Ribble Valley Borough Council
Housing & Development Control

Application no: **3/2024/0019**

Address: **Old Sawley Grange Gisburn Rd Sawley BB7 4LQ**

Proposal: **Approval of details reserved by conditions 4 (materials), 5 (boundary treatment), 8 (bat and bird boxes), 9 (EV charging points) and 10 (construction method statement) of Prior Approval 3/2021/0954 under class Q (a) and (b) for the conversion of the existing agricultural building to form 3 new dwellings.**

CONSTRUCTION MANAGEMENT PLAN

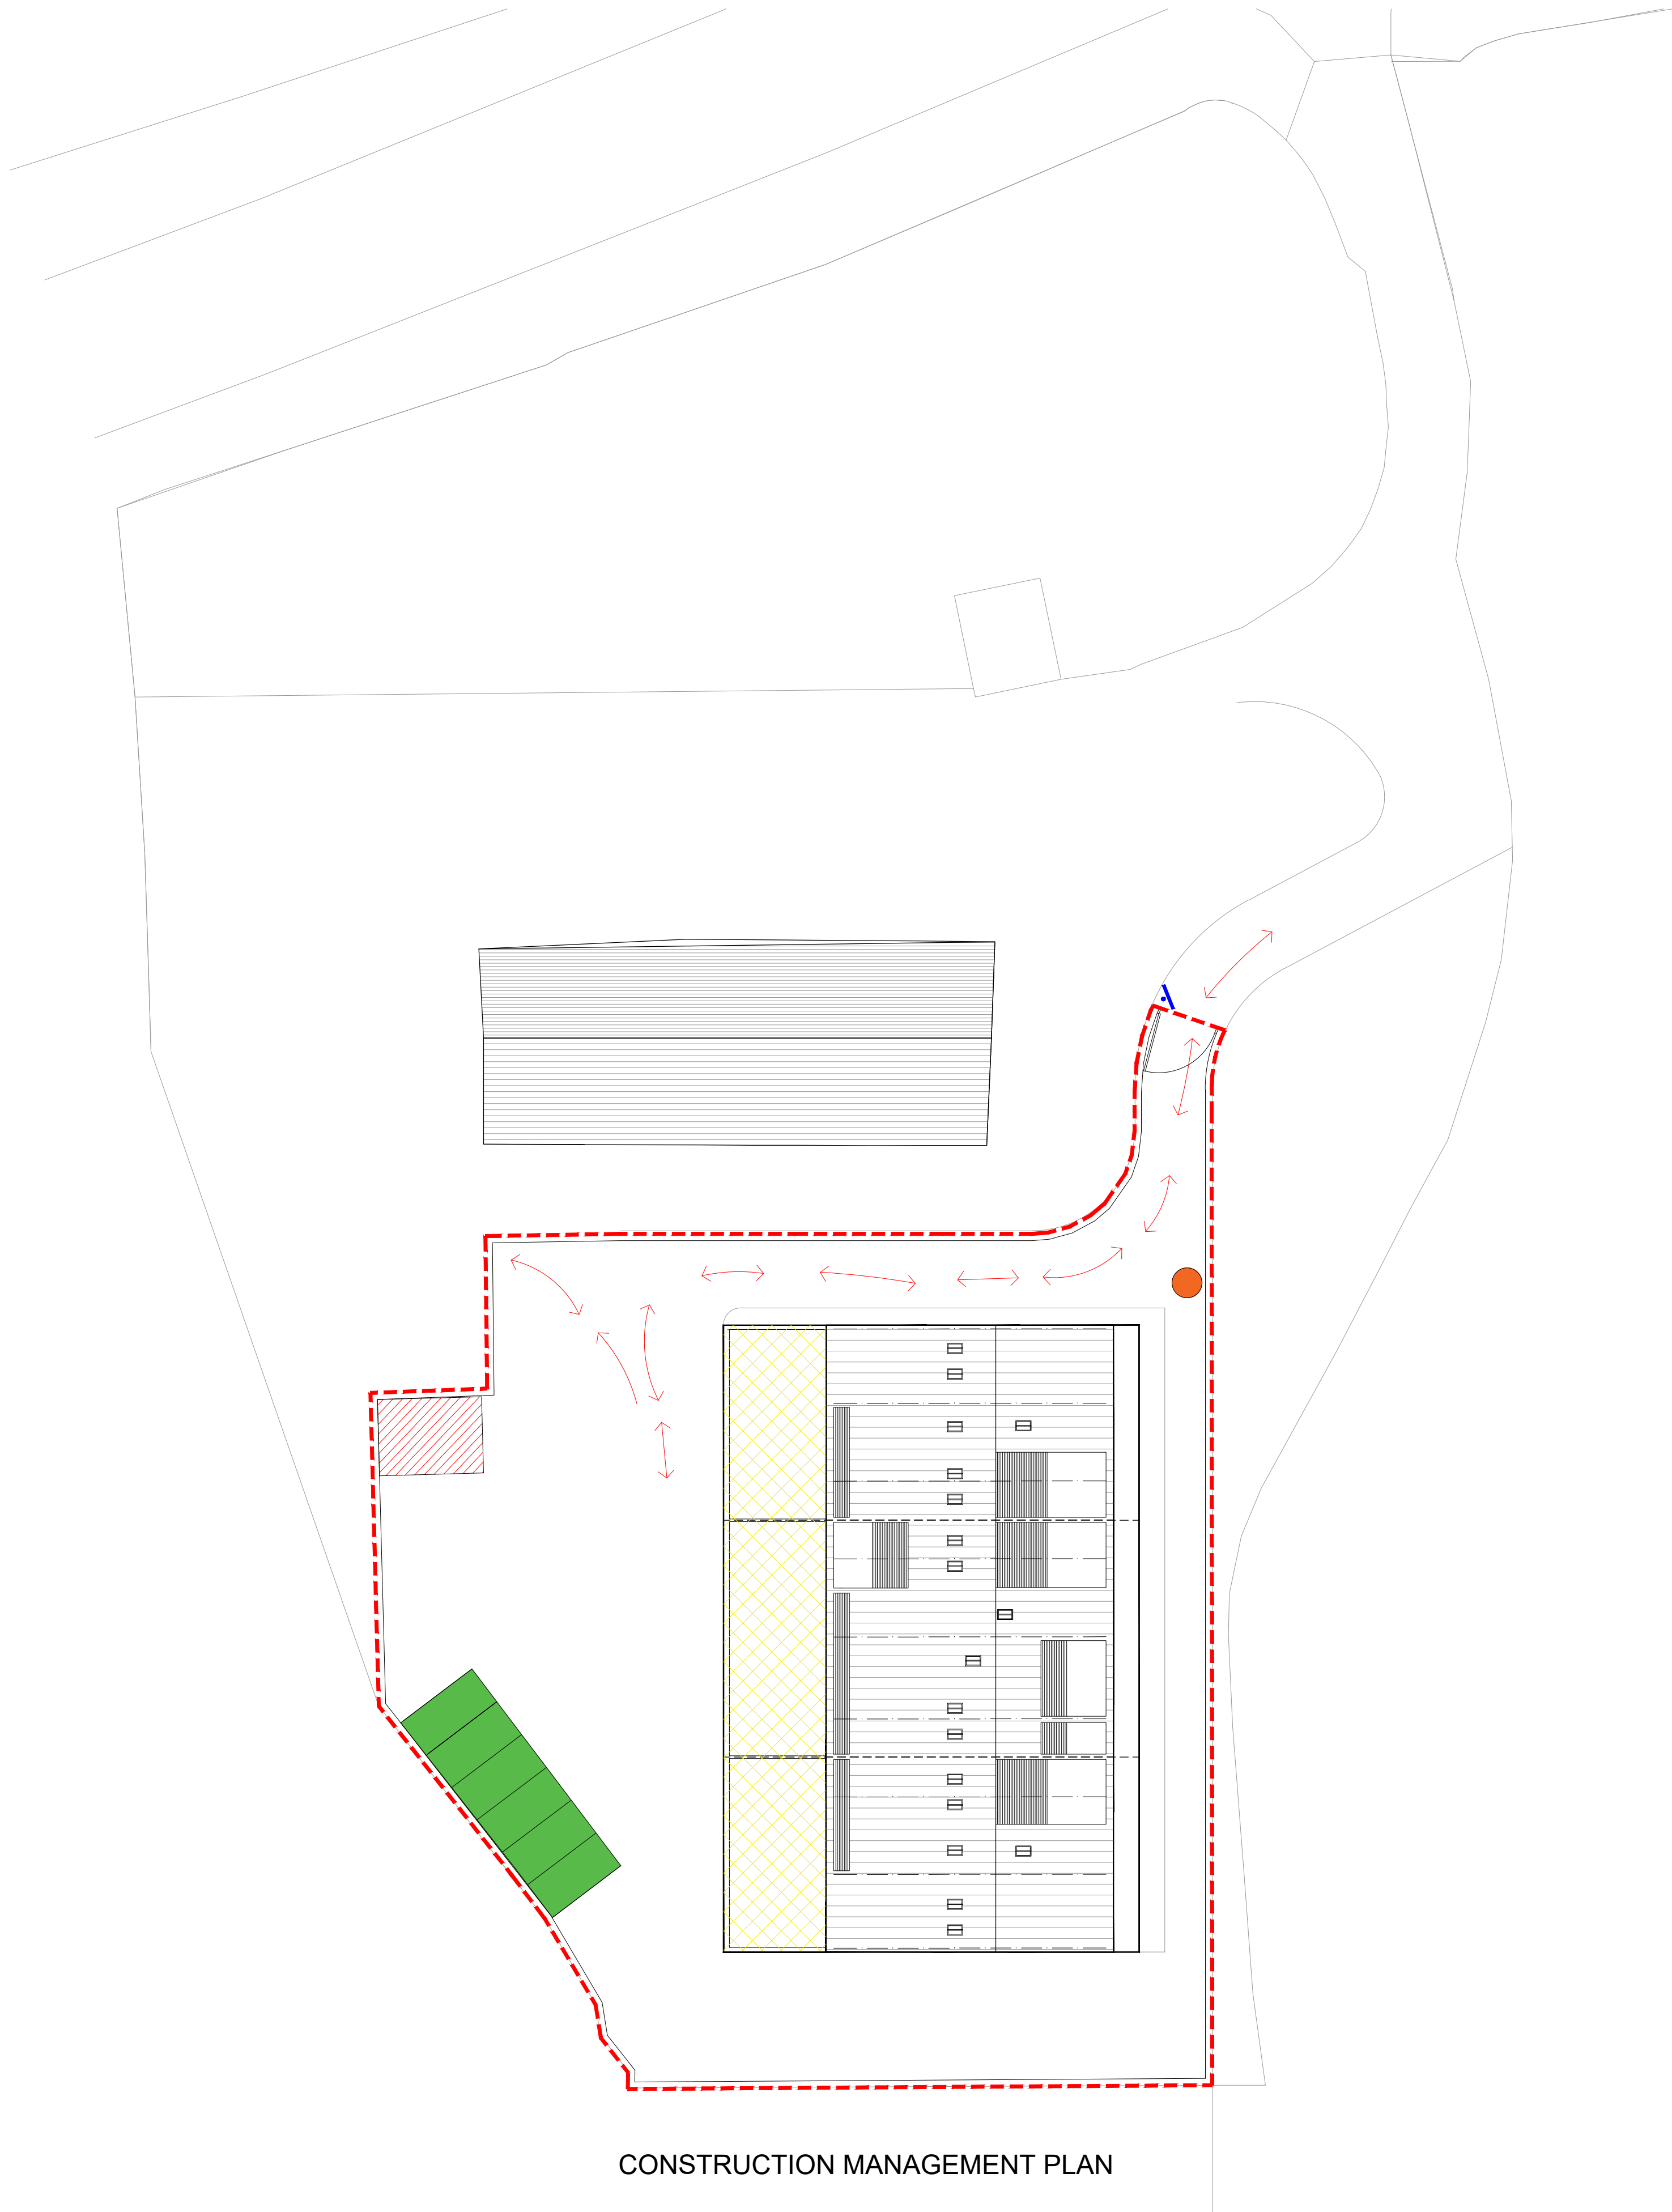
The LHA have reviewed the Construction Management Plan and have no objection to the discharge of condition but require the contact details of the site manager to be submitted to the Local Planning Authority (LPA) in case of emergency and to ensure that the details are on record.
